CITY OF ALBUQUERQUE

Re: Master Tech Auto
304 Candelaria Rd NW
Traffic Circulation Layout
Engineer's/Architect's Stamp 11-25-2019 (G14D093)

TRAFFIC CIRCULATION LAYOUT

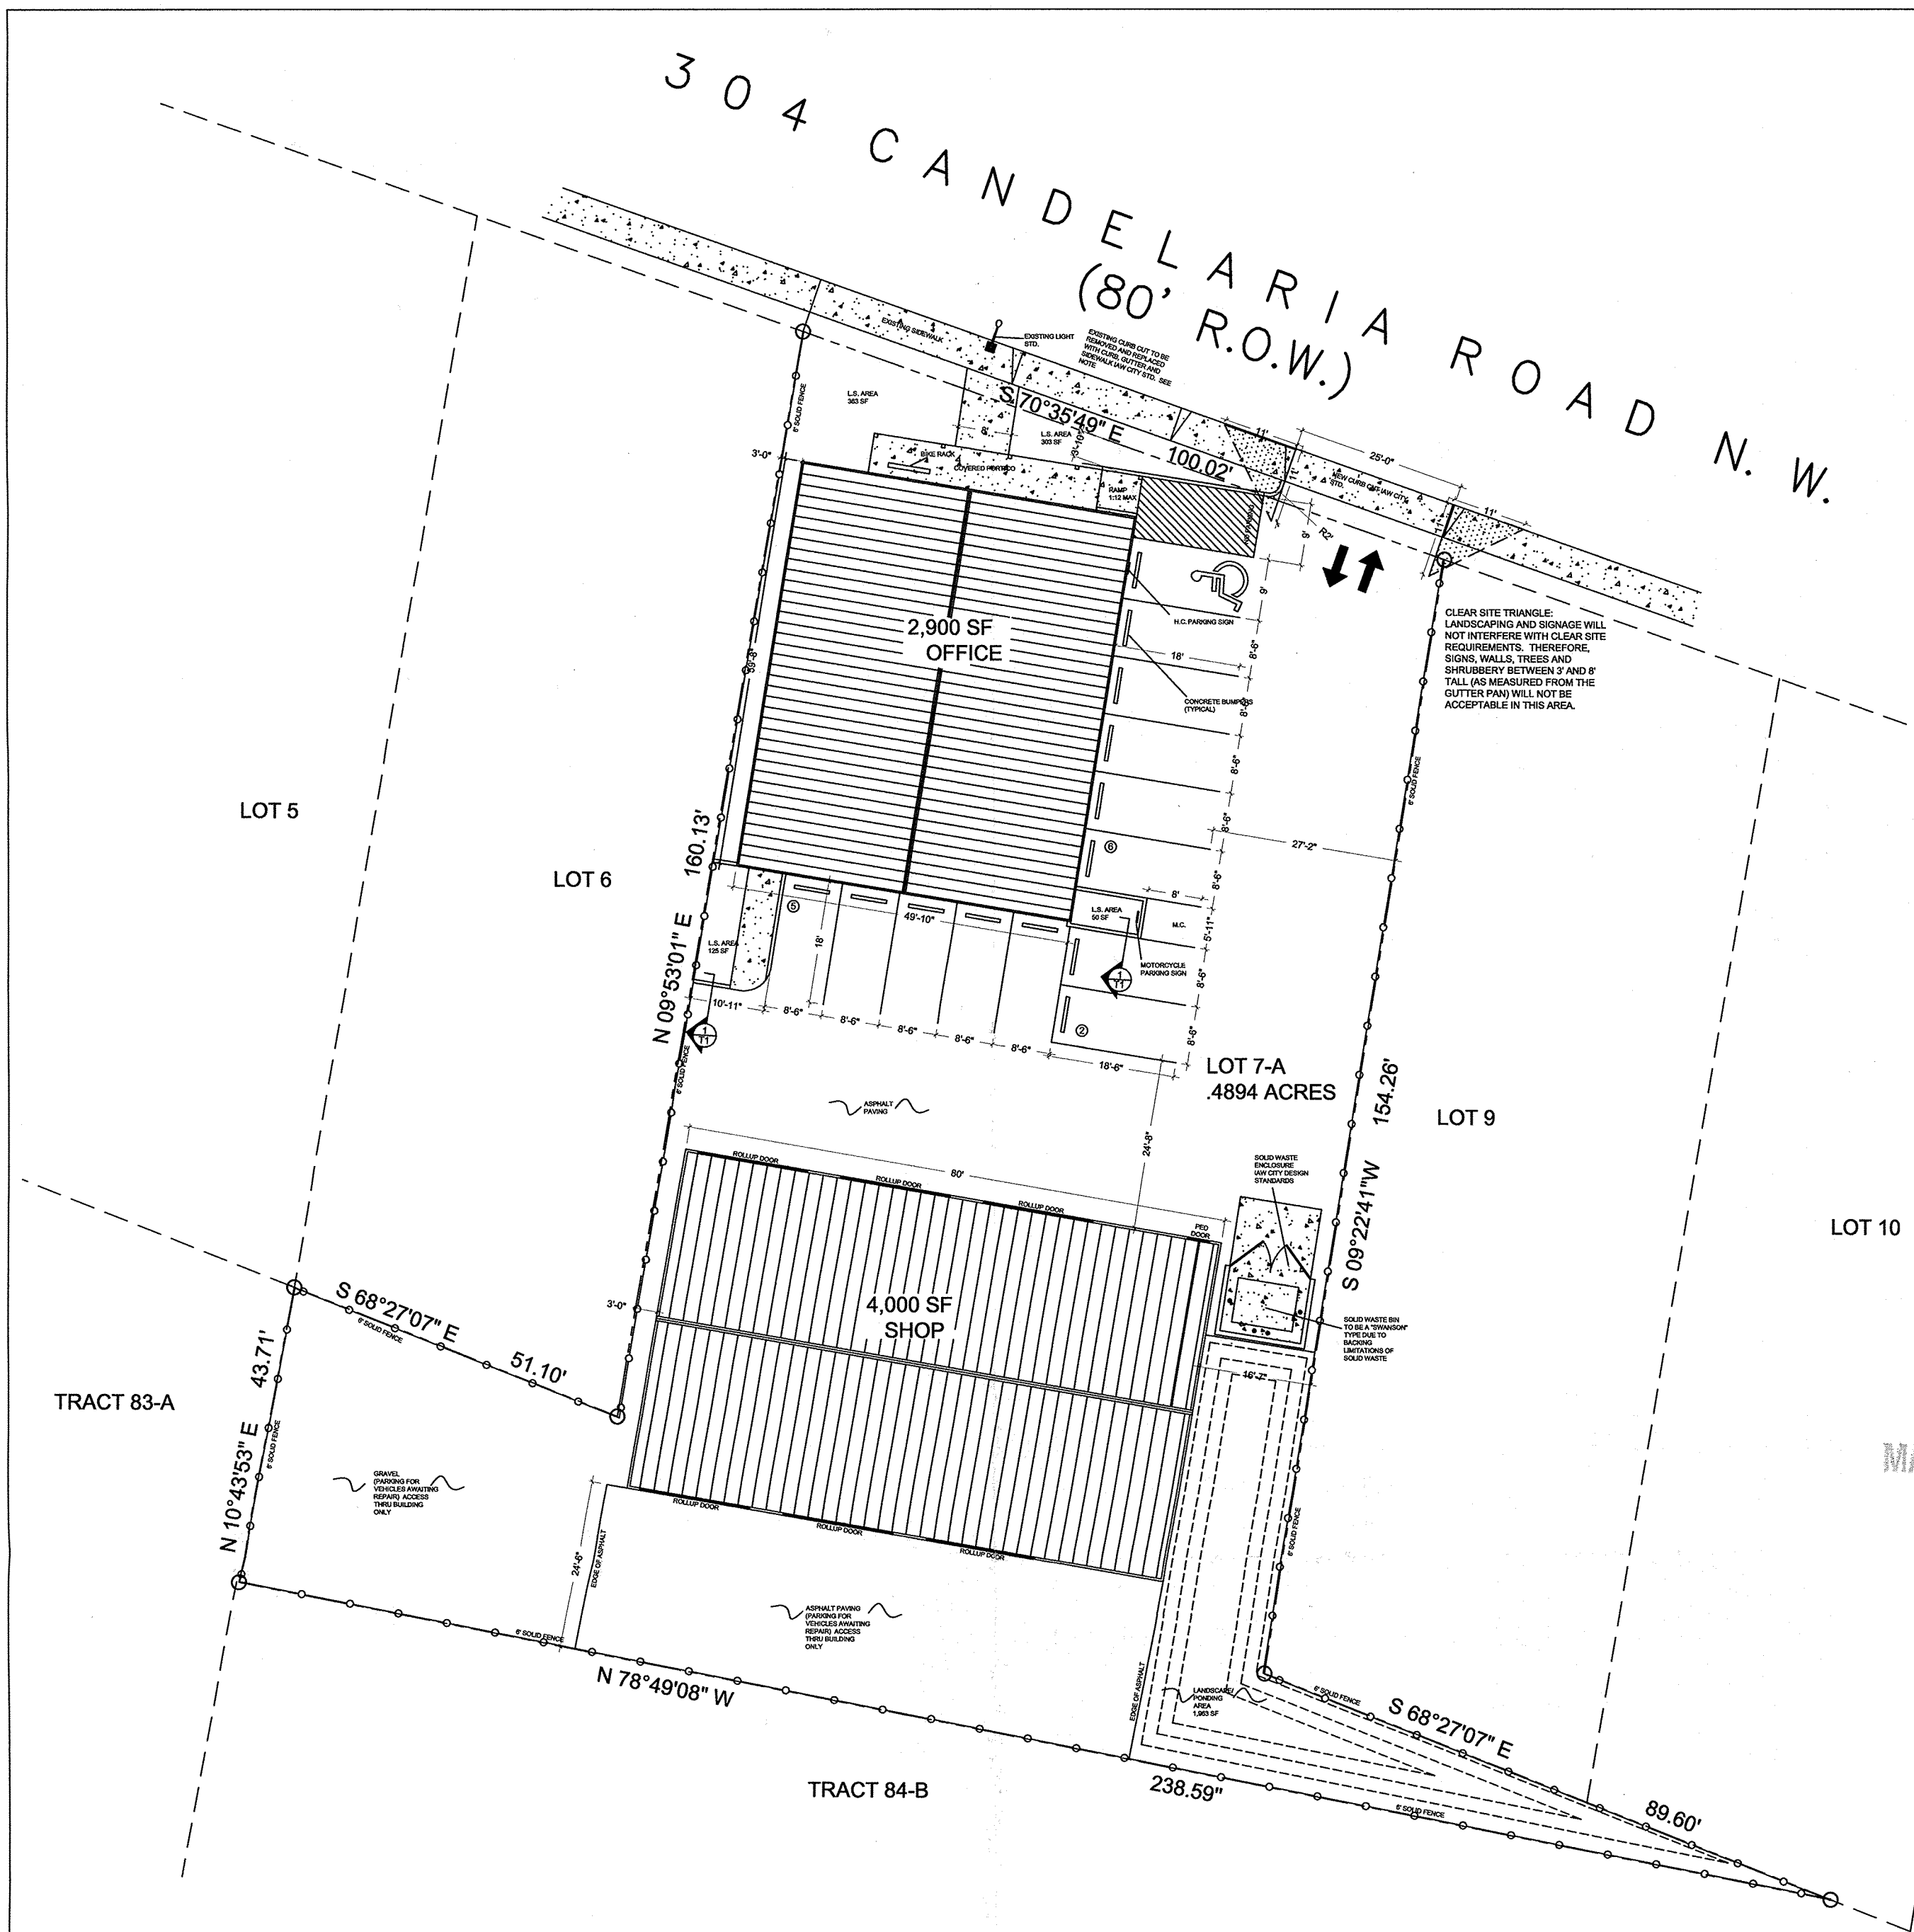
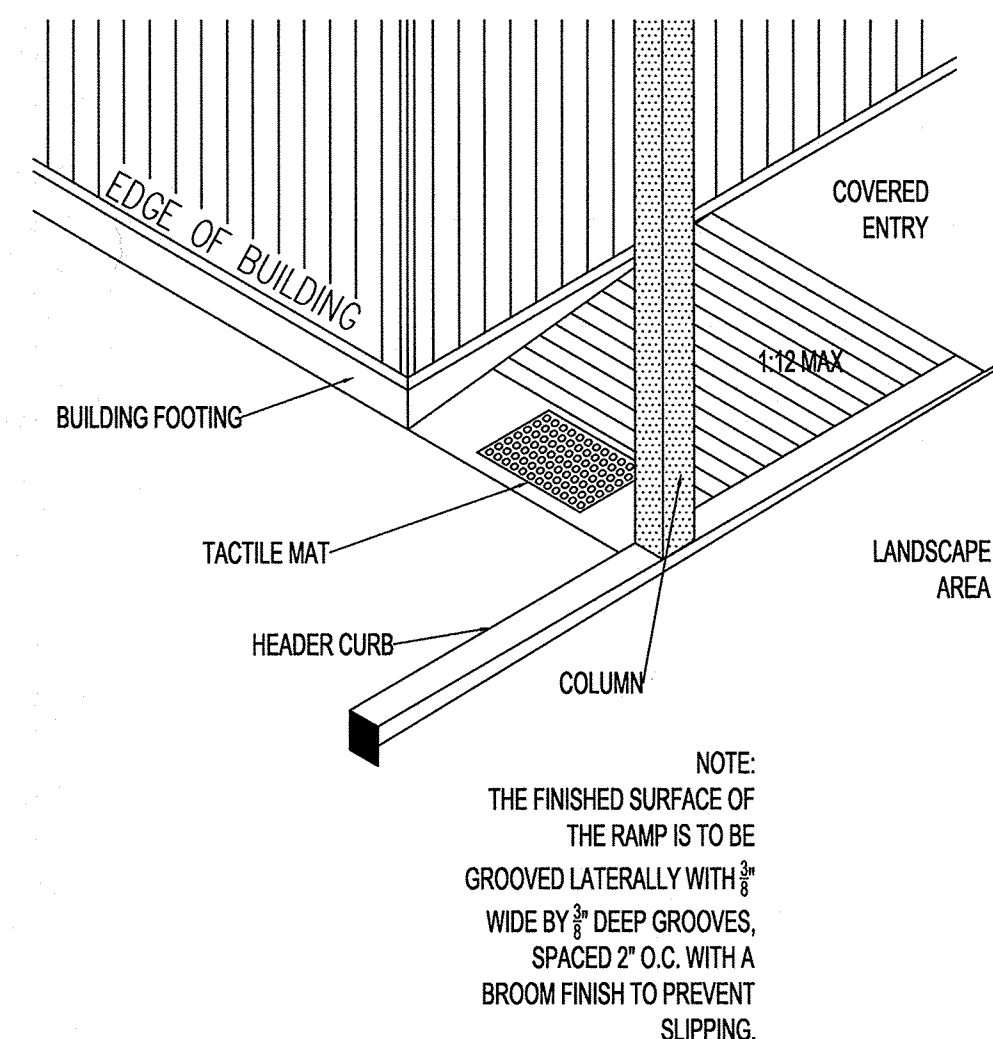
1. Show dimension of ADA accessible pedestrian pathway that is connecting the public sidewalk to the building entrances.
2. Refuse vehicle maneuvering shall be contained on-site. The refuse vehicle shall not back into the public right of way.; provide a copy of refuse approval.

3. Text for clear site triangle is too small.
4. Please add a note on the plan stating "All improvements located in the Right of Way must be included on the work order."

5. Unused curb cuts must be replaced with sidewalk and curb & gutter. A build note must be provided referring to the appropriate City Standard drawing.

6. Add a note stating "All broken or cracked sidewalk must be replaced with sidewalk and curb & gutter." A build note must be provided referring to the appropriate City Standard drawing.

7. At the south side of the lot, there are some areas for vehicle parking, are those vehicles accessing the area through the shop?
